Re: 203 Fore – Submission requirements
Lauren Swett
February 26, 2018

UTILITY PLAN LEVEL 01 - FORE STREET
1/16" = 1'-0"

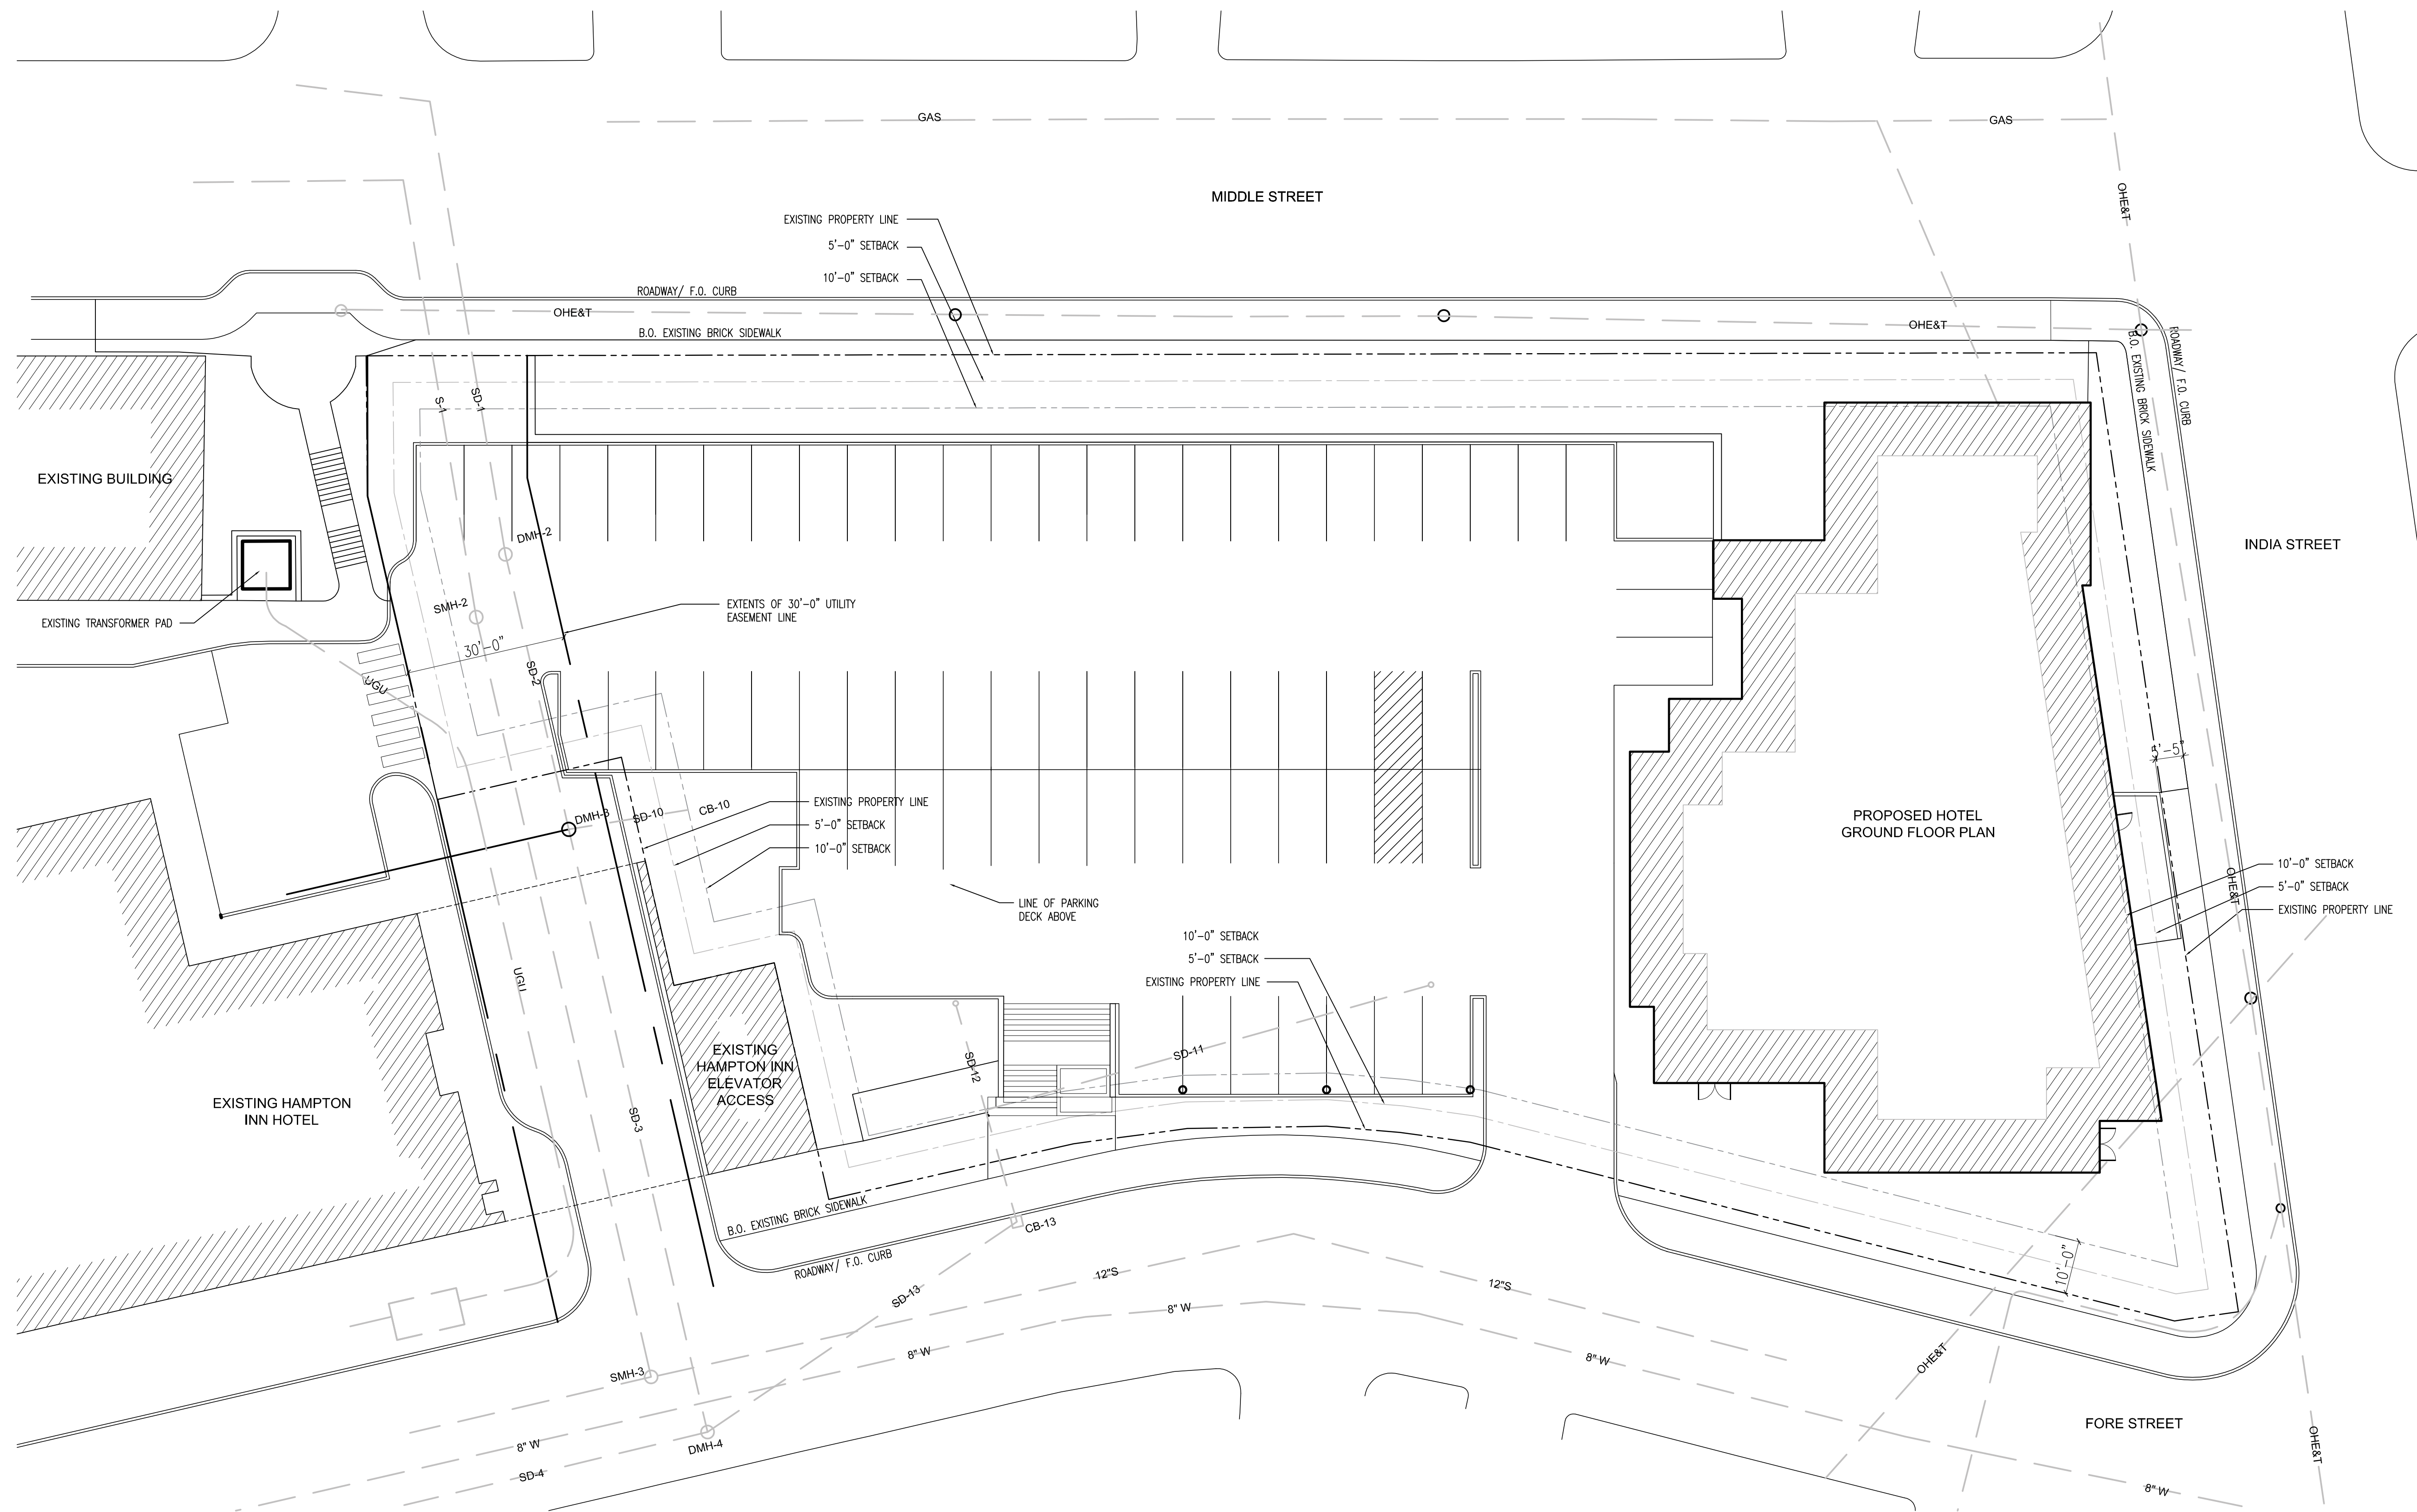
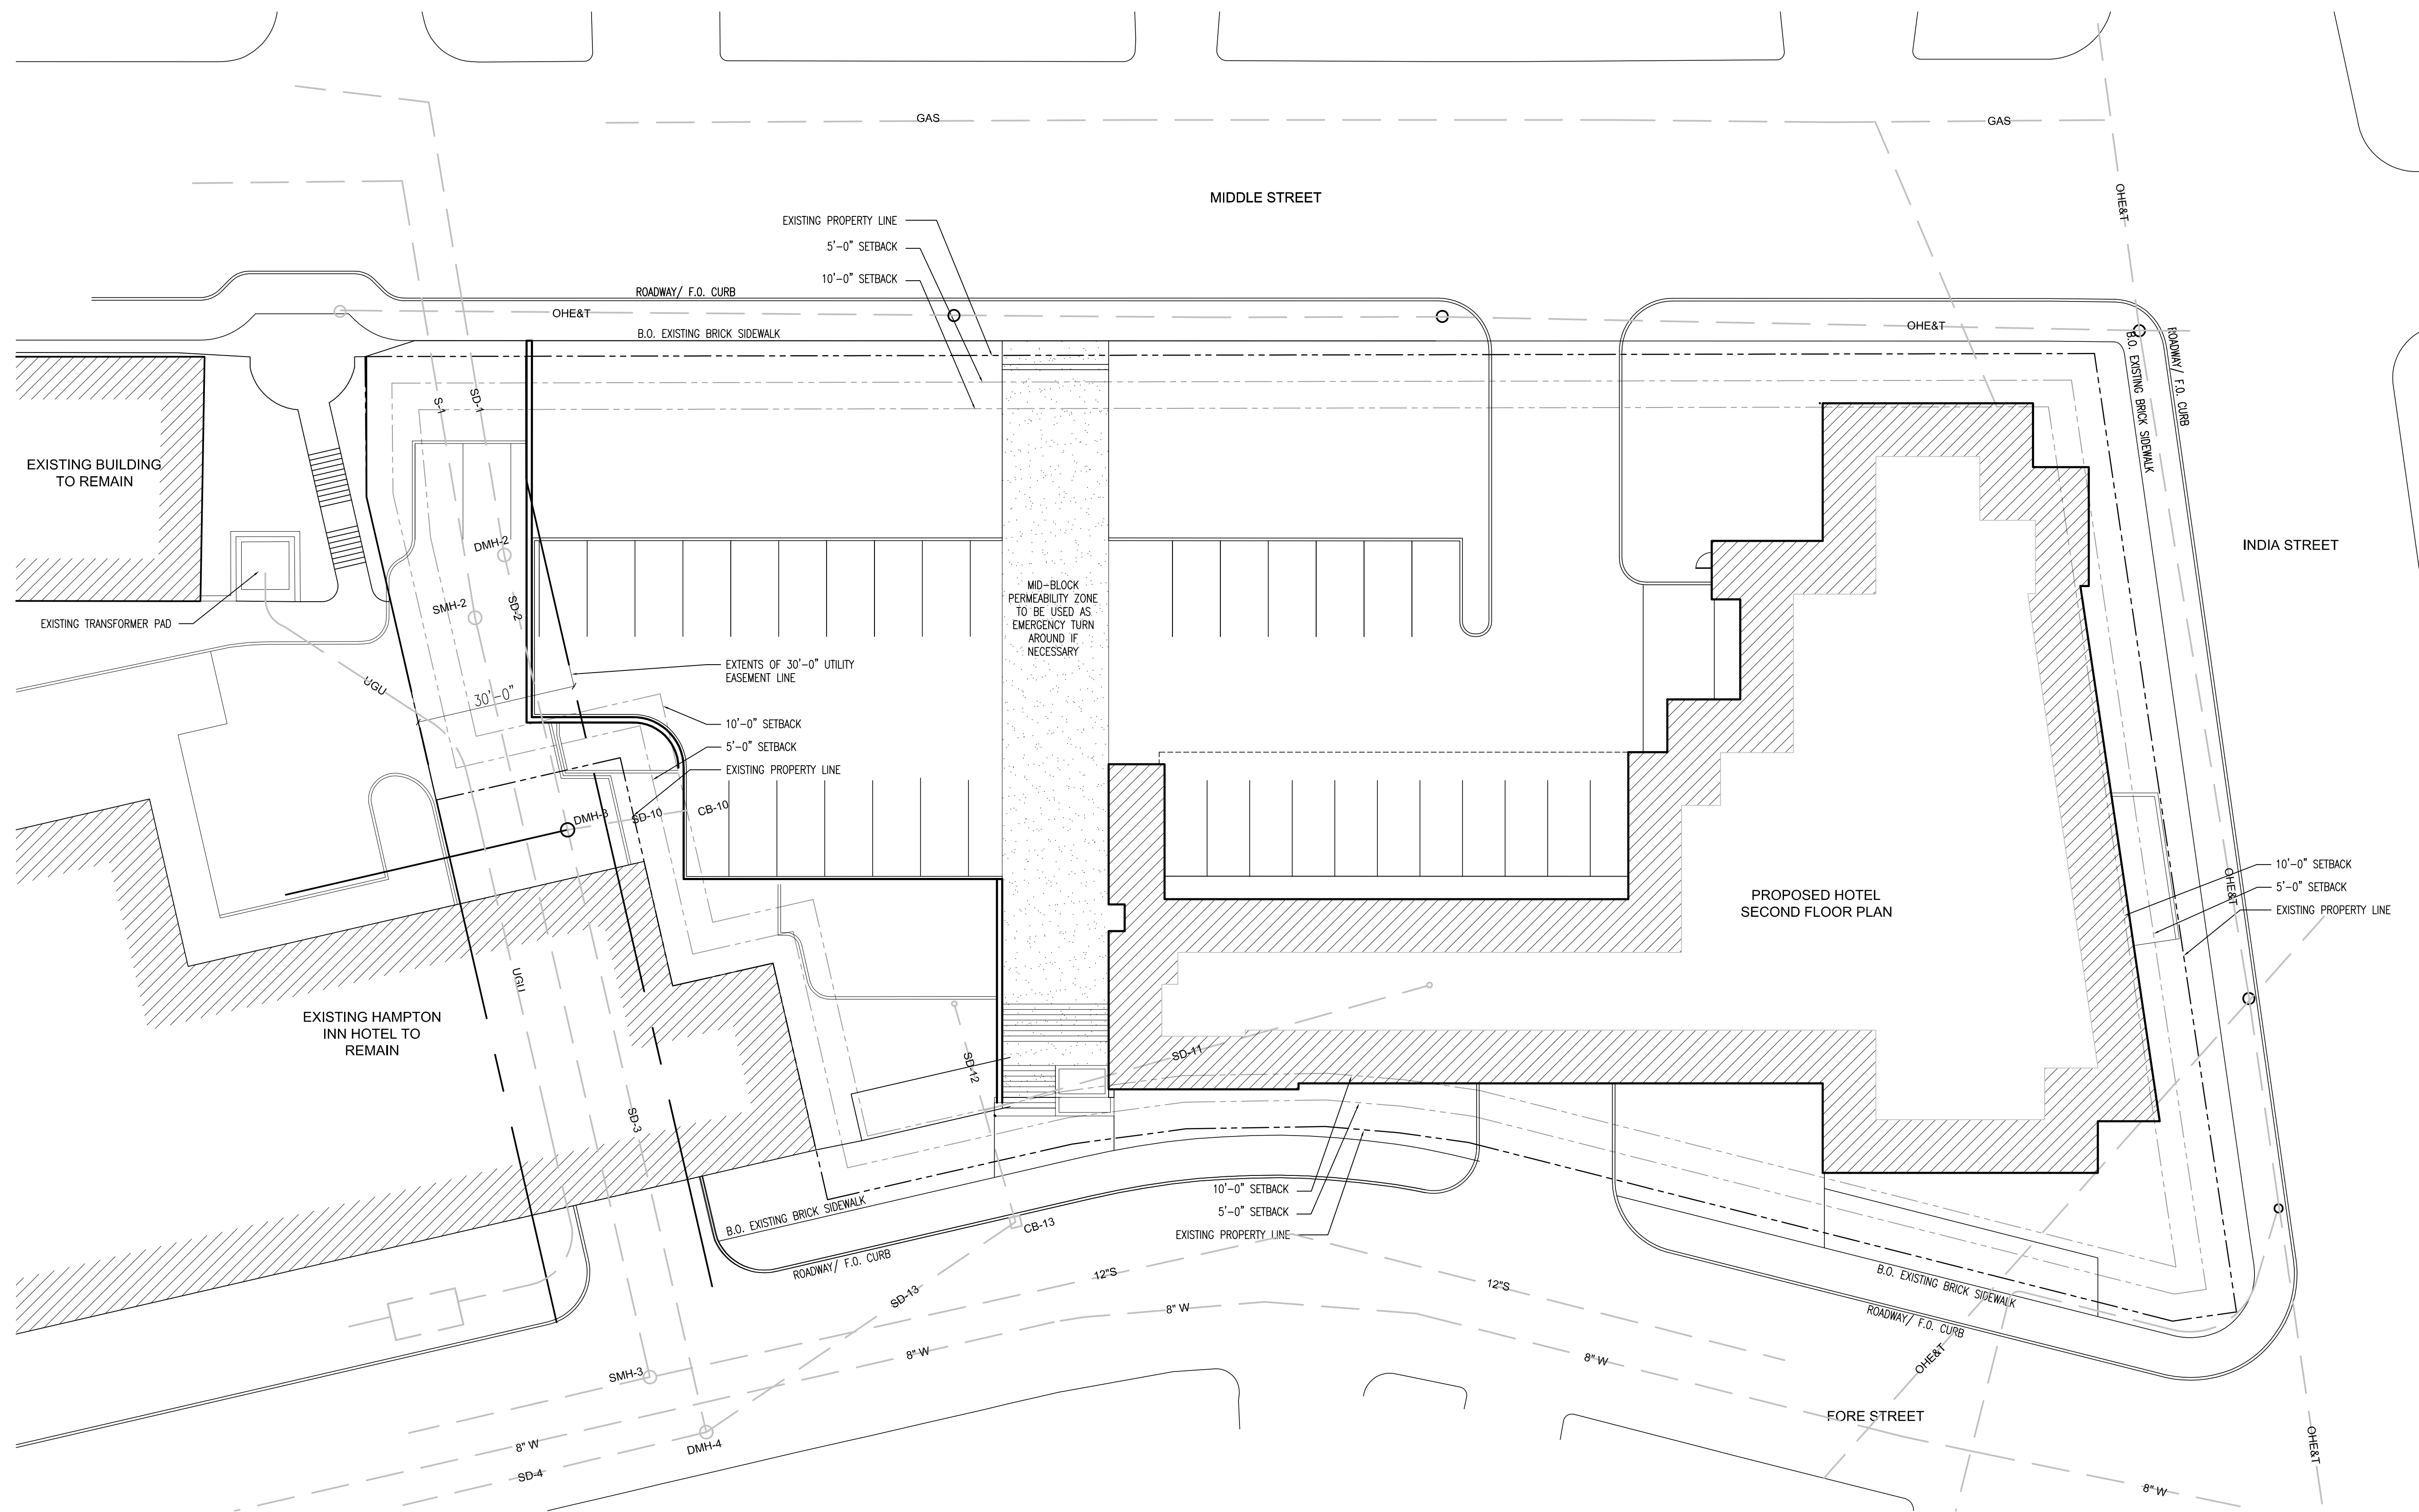
There are no plans stamped by an Engineer, they are all part of the architectural set. The grading plan is unclear (light on information and unclear on existing vs. proposed), and the utility plans still show construction of structure over utility easements.

They'll need to submit a complete engineering plan set, including details in conformance with the technical standards, and they'll need to provide a complete stormwater management plan. I'm guessing they'll trigger the increase in impervious surface and/or redevelopment standard. Also, looking at an existing utility plan they submitted, this project will get rid of treatment systems that were installed to treat the parking lot and surrounding areas. They'll have to take this into consideration in their stormwater management plan, and figure out what areas are being maintained that should still receive treatment.
